WEST SUSSEX COUNTY COUNCIL CONSULTATION

TO:	Arun District Council FAO: Mrs a Gardner
FROM:	Highways, WSCC
DATE:	14/08/2018
LOCATION:	Unit E1, The William Booker Yard, The Street, Walberton, West Sussex, BN18 0PF
SUBJECT:	WA/62/18/PL Continuation of A1 showroom use following 2 year temporary permitted development. This application affects the character and appearance of Walberton Conservation Area.
DATE OF SITE VISIT:	
RECOMMENDATION:	☒ Advice ☐ Objection ☐ Modification ☐ No Objection ☐ More Information ☐ Refusal
S106 CONTRIBUTION TOTAL:	£N/A

Drawing No PTP/1802/02

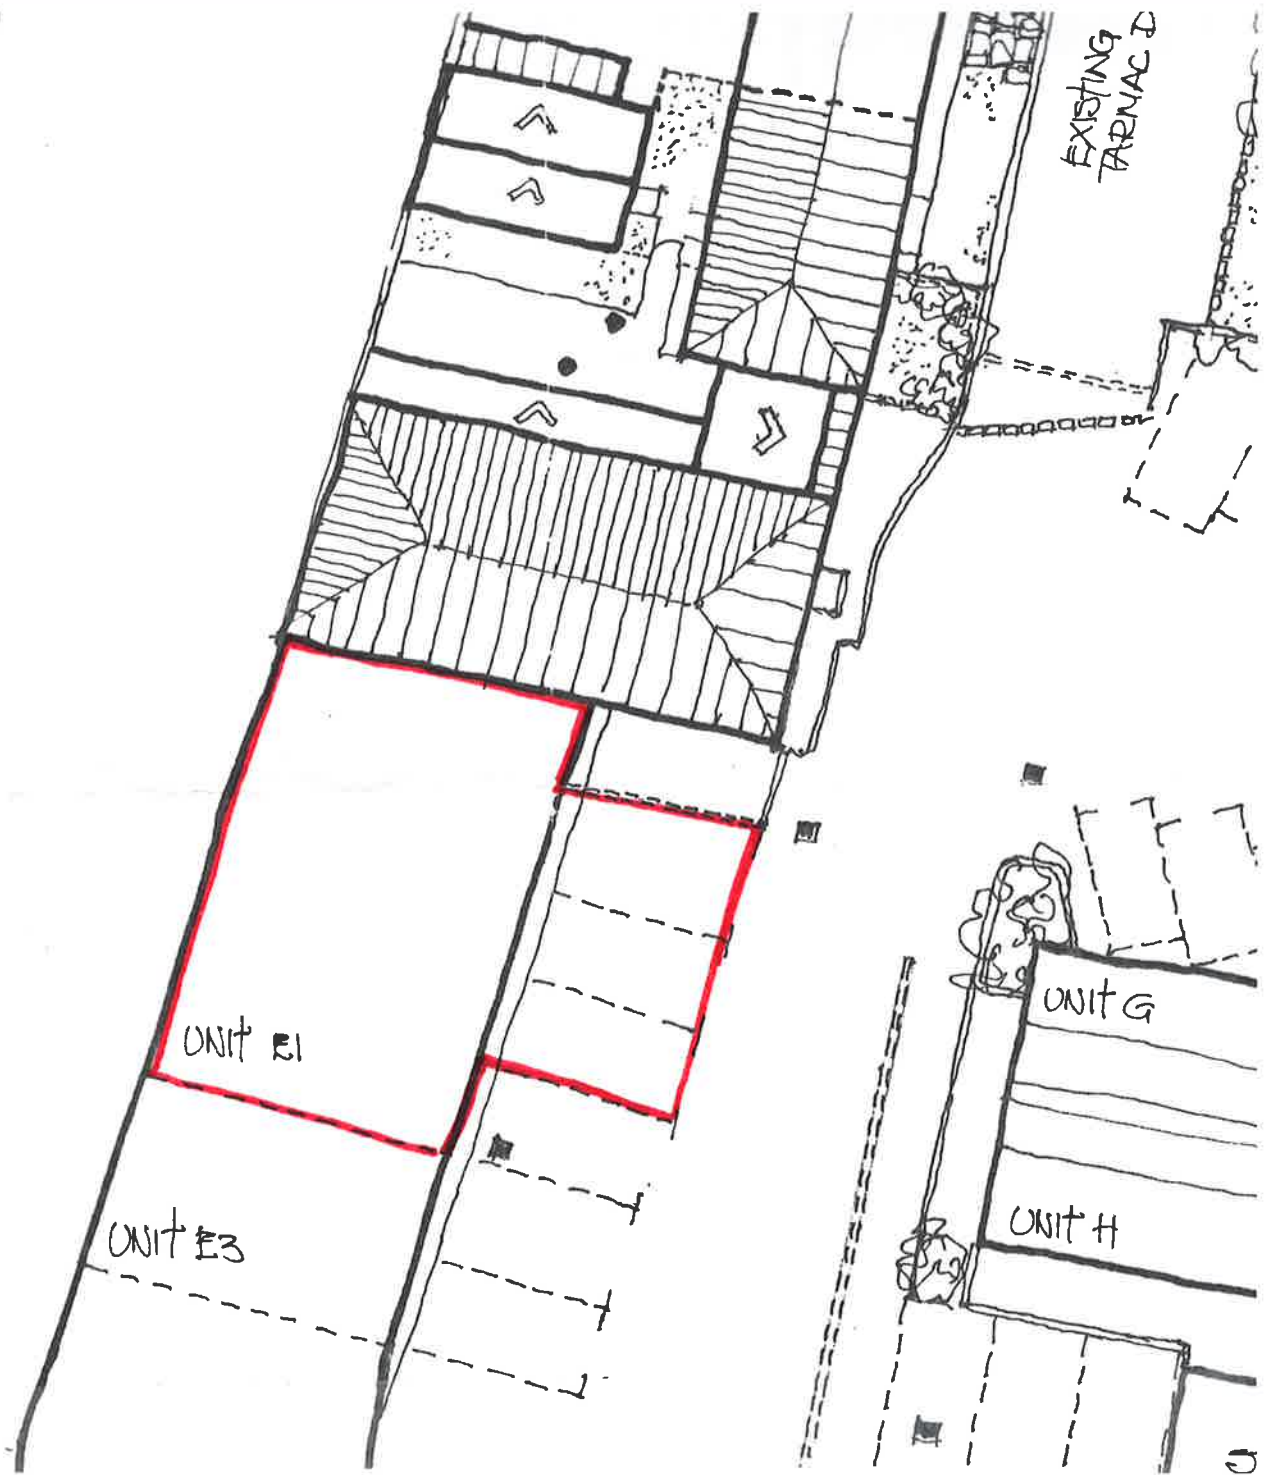
The parking provision remains unchanged over the arrangement that has served the unit for the past 2 years; this allows three parking spaces for workers and visitors of the unit. The LHA is unaware of any highways capacity concerns in the local area however overspill parking would not be considered to be to such an extent that all parking within the site would be used.

within the Unit. Deliveries are typically one large van (no HGV's) per week which can be accommodated for within the associated parking and turning area.

Based upon the above consideration, the LHA raise no objections to the proposal.
